**Comments on Responses
Submitted for Deadline 3**
on Behalf of the
**Neighbours and Users of
Queen Elizabeth Park**

Interested Party reference no: **20022545**

1. General Arrangement Plans (3 of 3)¹

Appendix QE.2.7.1: Works Plans - Addition of Queen Elizabeth Park Access (Sheet 35 & 106)

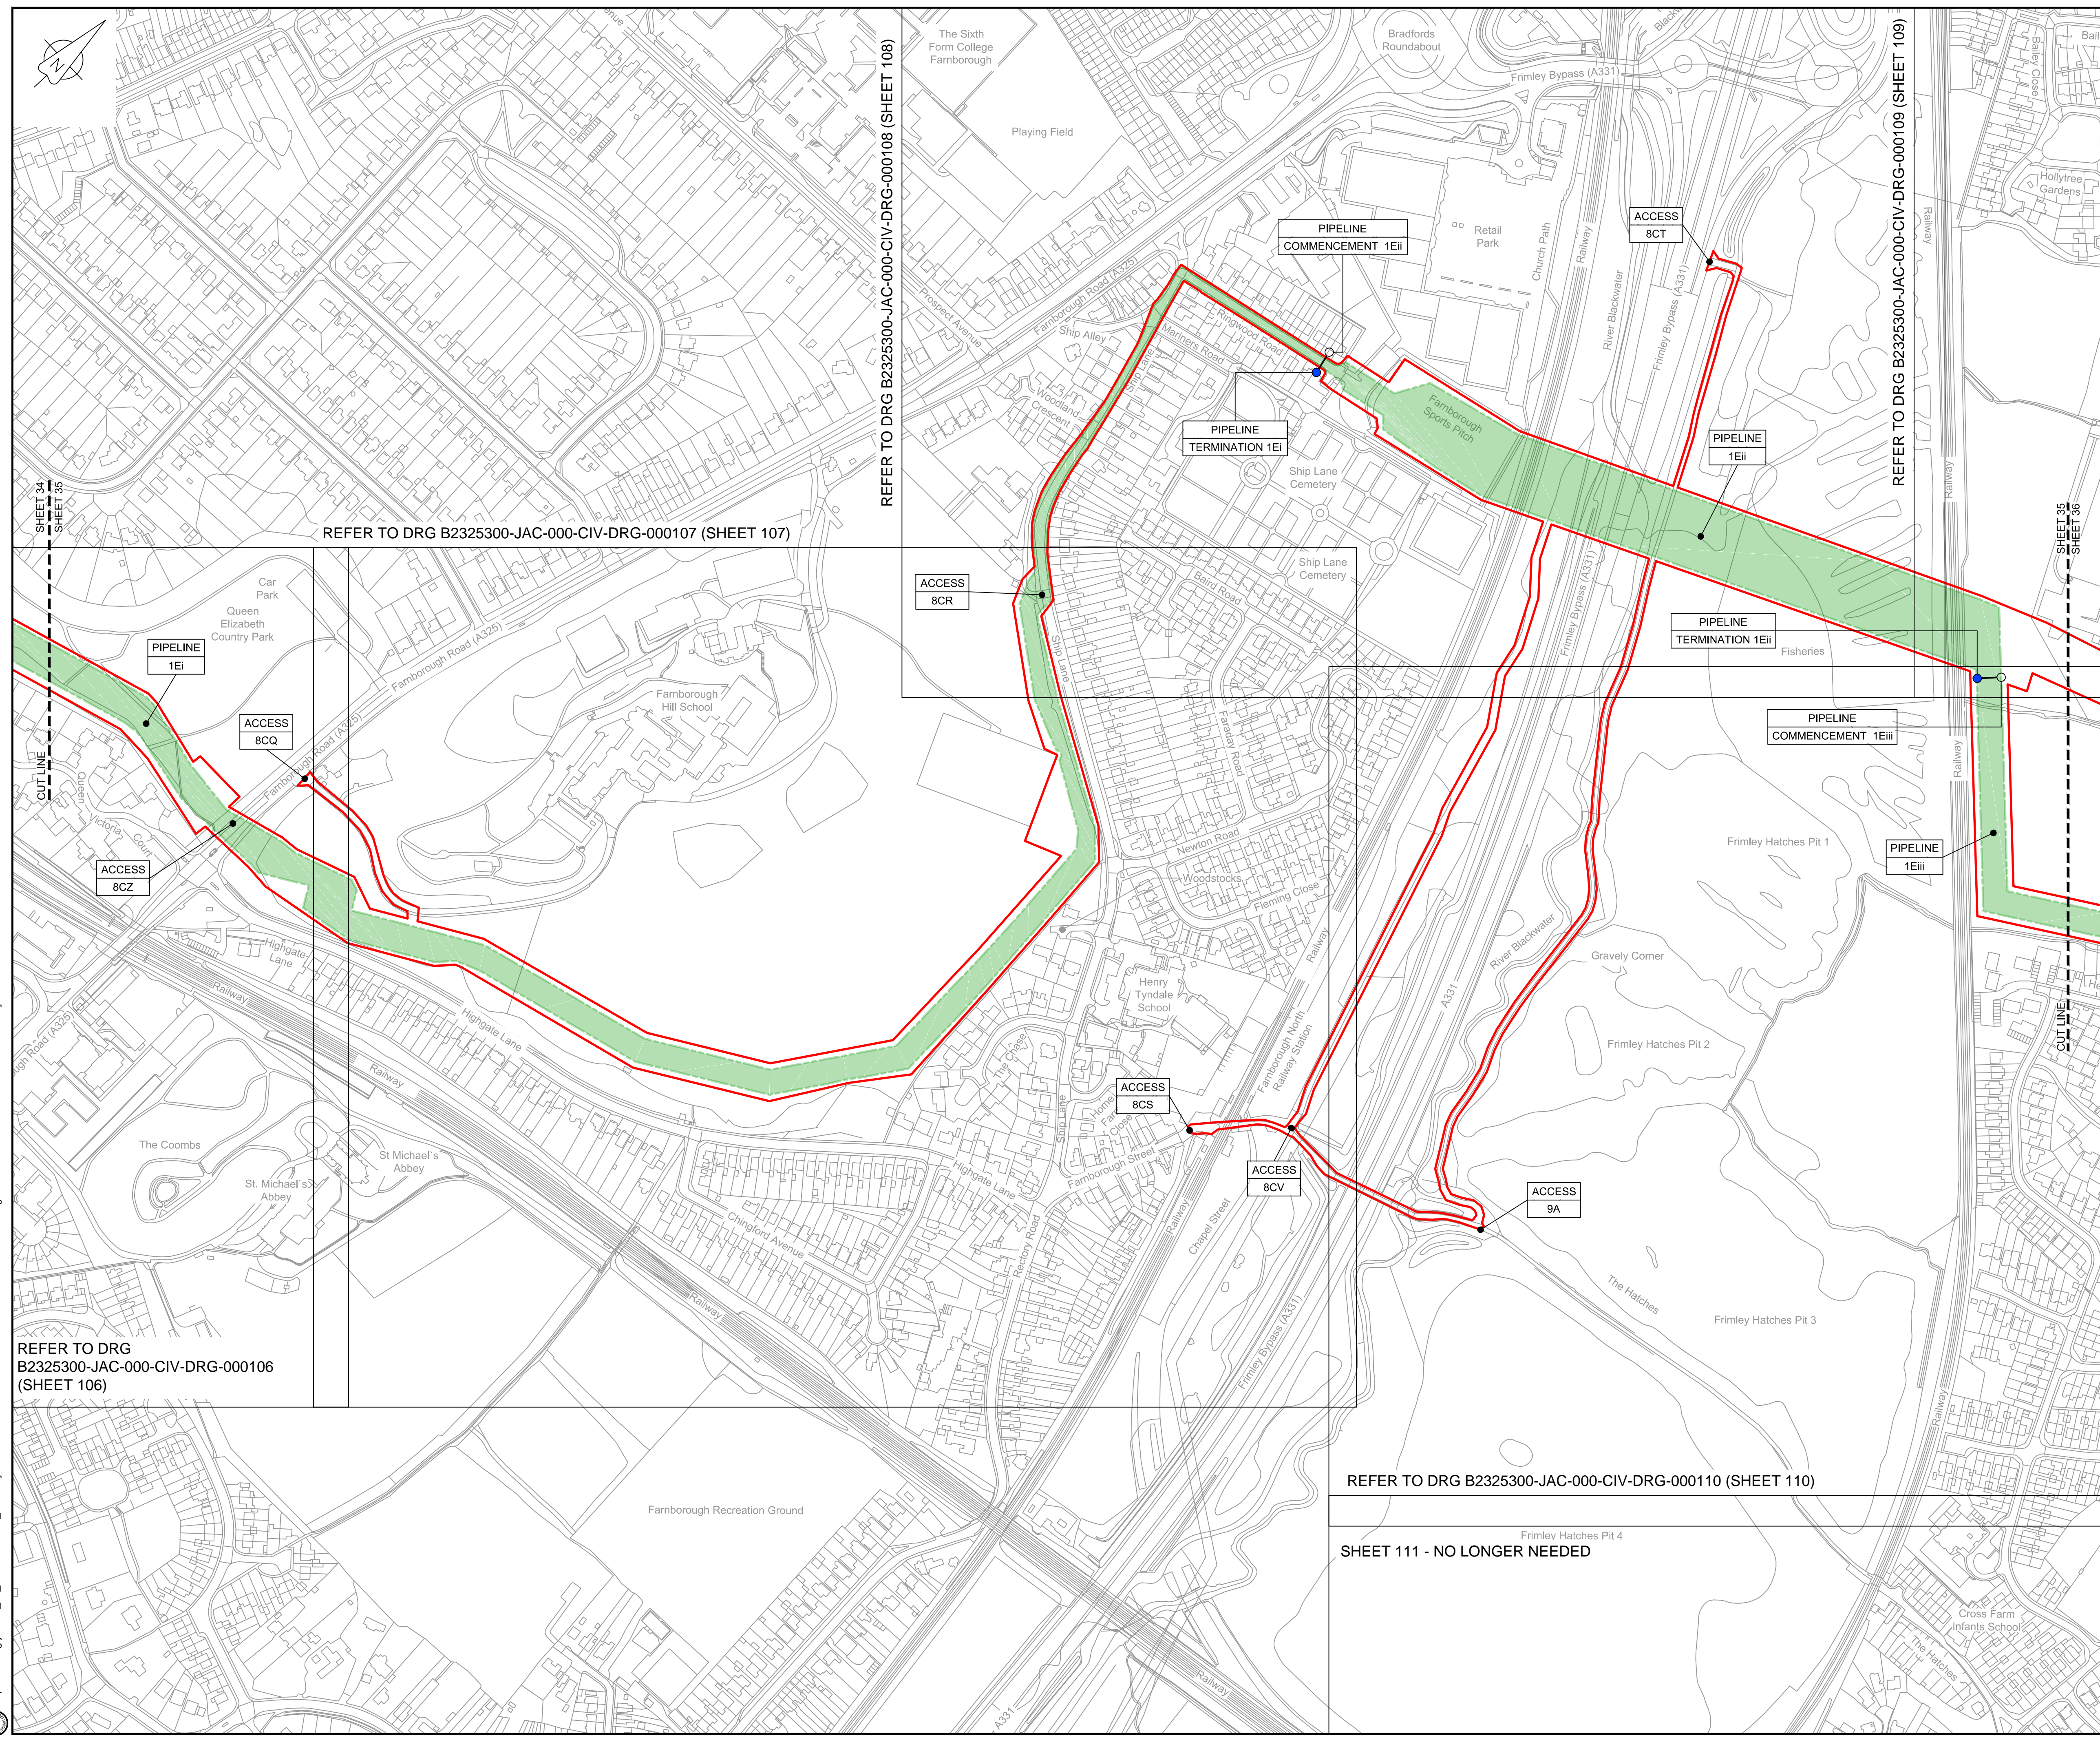
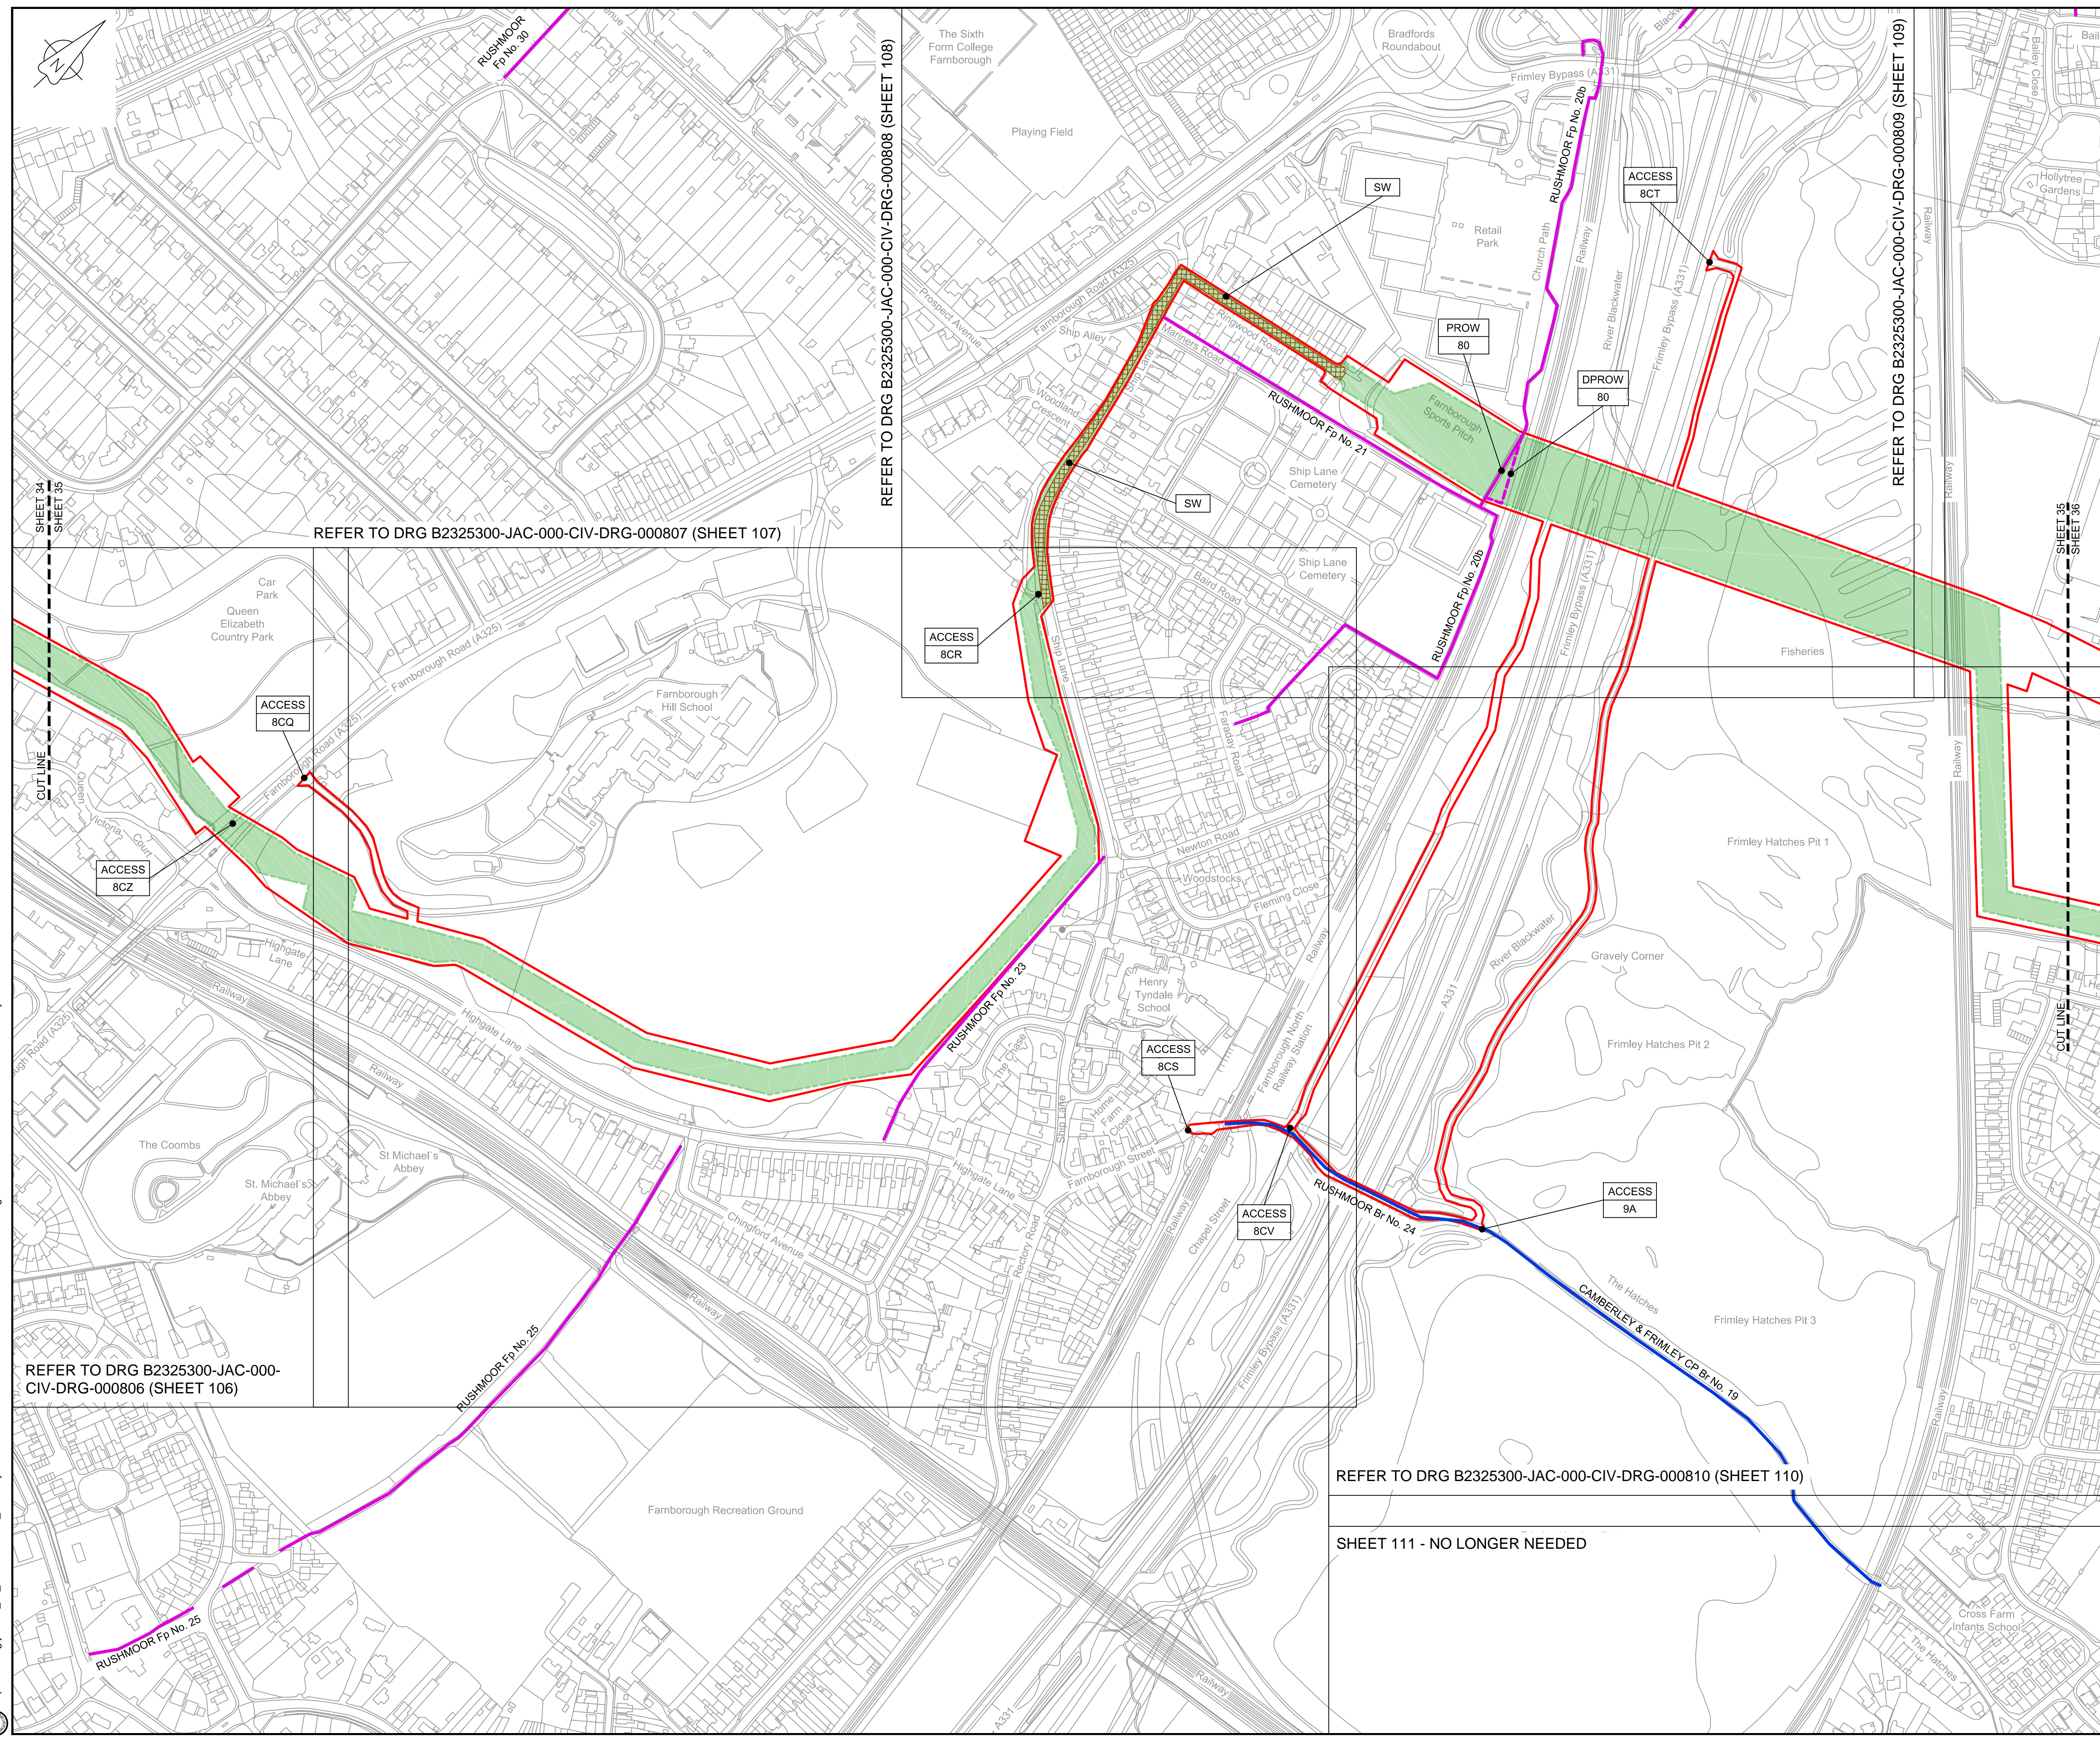
Queen Elizabeth Park has been identified by the Examining Authority as a 'hotspot'. We are therefore disappointed to see that it is not represented in detail on a single sheet in the General Arrangement Plans. Instead it is split across sheets 34 and 35. Sheet 106 shows the majority of the park but it would be more useful if it showed the entire park.

1. Rushmoor Borough Council TPO 194, which covers Queen Victoria Court and extends to the order limits has not been included. This should be shown on sheets 34, 35 and 106.
2. Rushmoor Borough Council TPO 386 covers an area adjacent to the north side of Queen Elizabeth Park. Due to its proximity to the Order Limits, it would be useful to show this too.

On Sheet 106, we note that both the narrow working area and stringing area run through T42 (the Fairy Tree).

1. There is no indication of what the T42 circle indicates. This appears to be neither the trunk size nor the size of the canopy, nor the root protection zone.

2. Likewise, there is no indication of what the spot at the centre of the T42 circle indicates. We assume this is the centre of the trunk but there is no confirmation of this.

3. We are doubtful that the position of T42 is accurately shown by this map. In reality, we believe it is closer to the southern boundary of the park than indicated here.

4. The plans do not show veteran tree 197352 (Beech, pollarded), which was added to the Woodland Trust's Ancient Tree Inventory on 4th November 2019 and pointed out during the Accompanied Site Inspection on 26th November. It is located within the narrow working area, near the 'elbow' on the left of the plan extract.

5. The stringing area (indicated in green) is wider than the narrow working area within it (indicated in pink). We assume that the pink area is 5 metres wide, which means the stringing area must be wider than that - and therefore wider than the width committed to in NW17.

6. The 5 metre width within the stringing area and the 10 metre pipe installation width both intersect with the circle indicating T42.

7. The works around T42 are mitigation B3 in the hierarchy in Esso's Technical Note on Ancient Woodland and Veteran Trees² (Table 5.1). It is our view that B1 should be used, meaning no digging or compacting activities in the buffer area. This means that both the trench and stringing area must be located elsewhere.
8. Veteran Tree 197352 will also require a suitable buffer zone, which will affect the location of the trench area.
